Fire Marshal Division

Re: Cagle Furniture Carnival 2019
107 Carletta Cagle Drive
Spout Springs, NC 28326

Application Number FMFW2104-0004

complete
 side plan

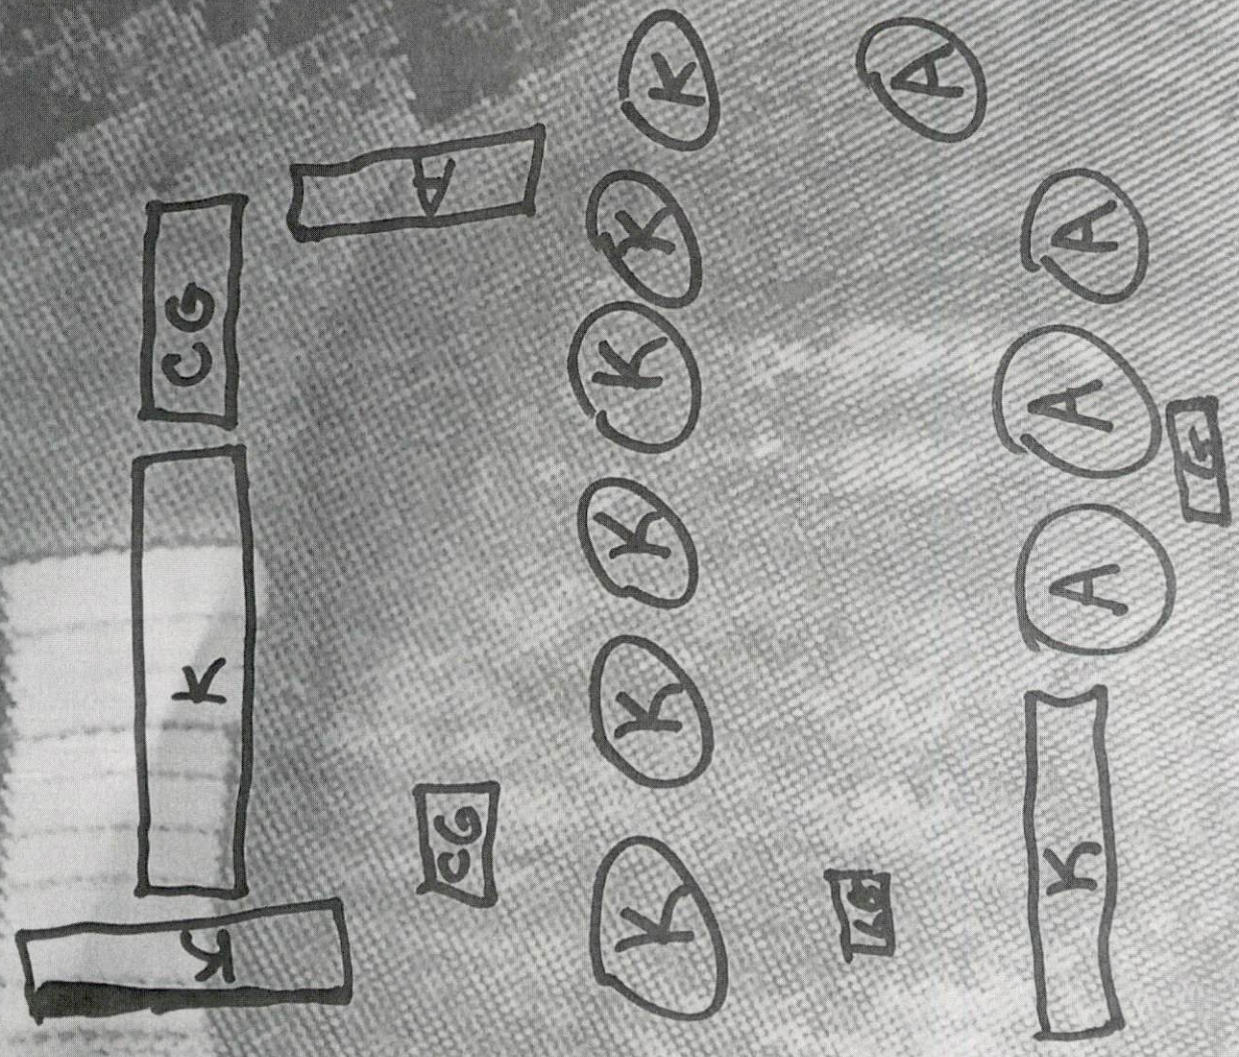
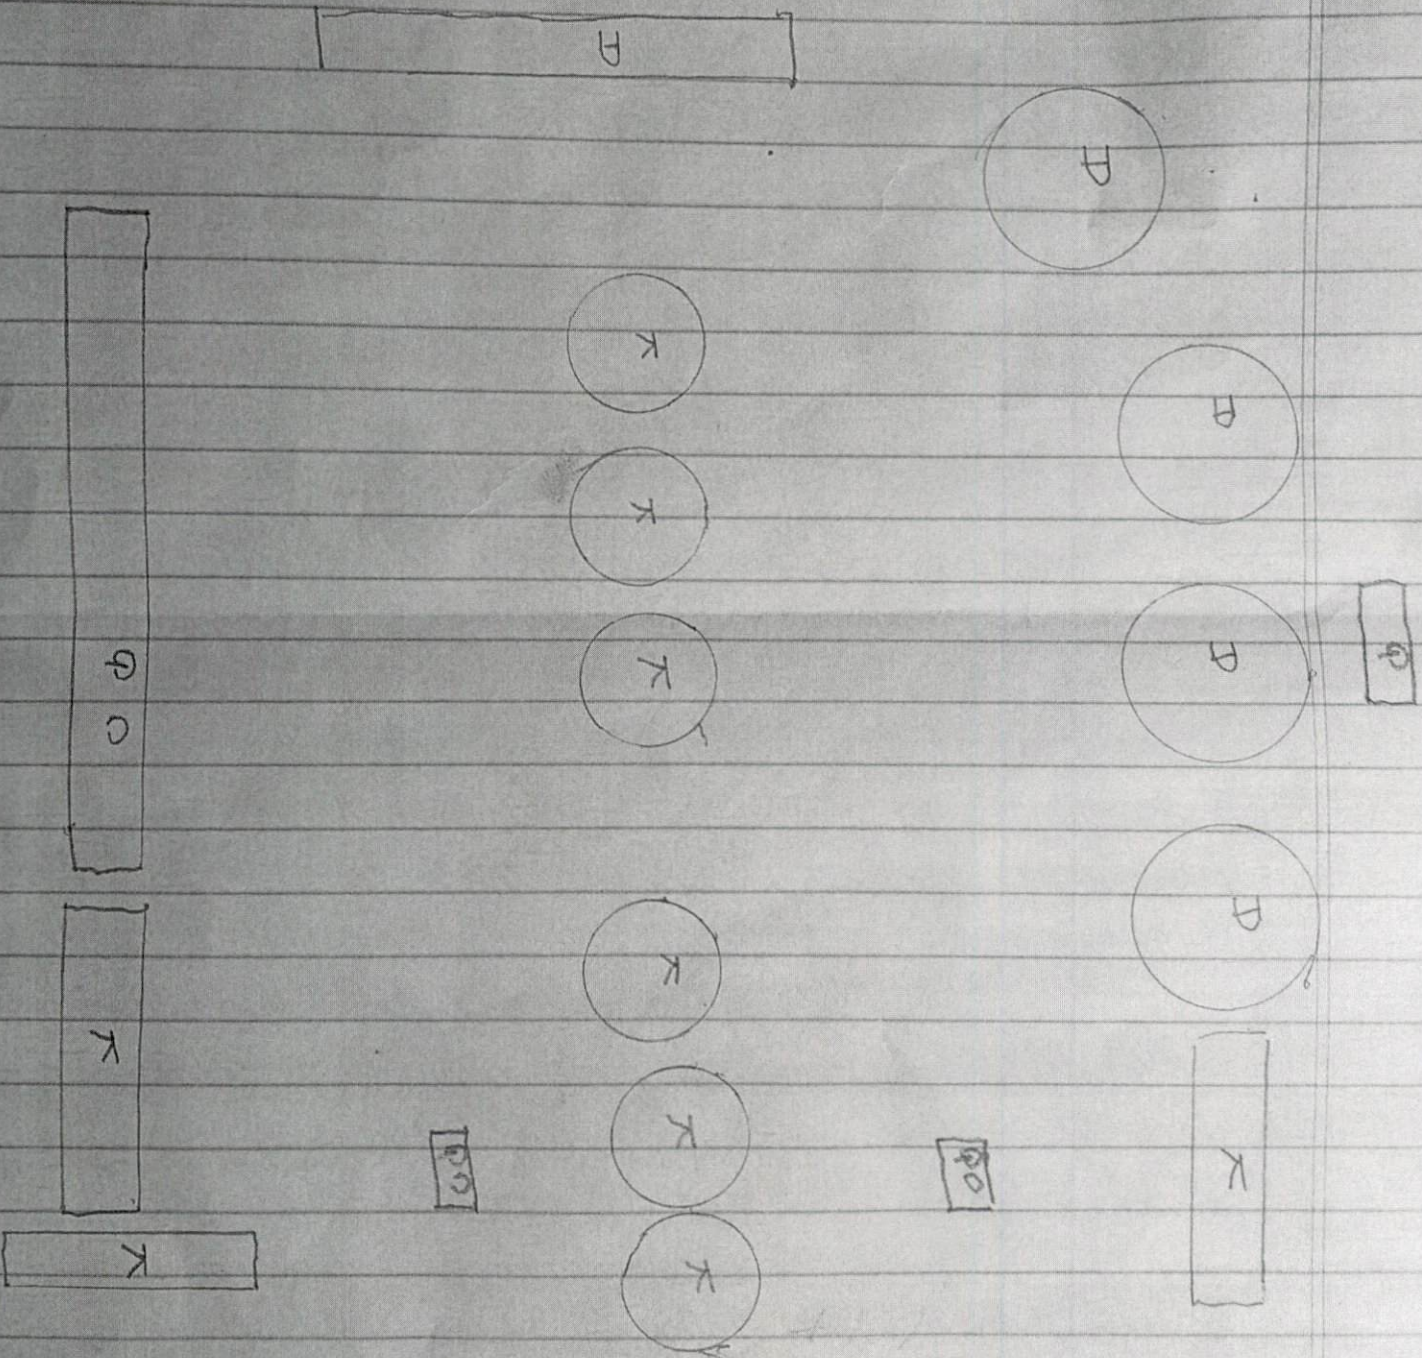
- Portable fire extinguishers shall be provided within a 30-foot (9144 mm) travel distance of commercial-type cooking equipment. Cooking equipment involving vegetable or animal oils and fats shall be protected by a Class K rated portable extinguisher.
- 2A-10B:C fire extinguisher shall be placed at tents/canopies with a travel distance not to exceed 100' from any fire extinguisher.

- **2411.5 Cooking tents.**
 - Tents where cooking is performed shall be separated from other tents, air-supported, air-inflated or tensioned membrane structures, temporary membrane structures or canopies by a minimum of 20 feet (6096 mm).

- **2411.6 Outdoor cooking.**
 - Outdoor cooking that produces sparks or grease-laden vapors shall not be performed within 20 feet (6096mm) from a tent, air-supported, air-inflated or tensioned membrane structure, temporary membrane structure or canopy.

- **2415 Generators**
 - Generators and other internal combustion power sources shall be separated from tents, air-supported, air-inflated or tensioned membrane structures, temporary membrane structures or canopies by a minimum of 20 feet (6096 mm) and shall be isolated from contact with the public by fencing, enclosure or other approved means.

- **2413.3 Refueling.**
 - Refueling shall be performed in an approved location not less than 20 feet (6096 mm) from tents, air-supported, air-inflated or tensioned membrane structures, temporary membrane structures or canopies.
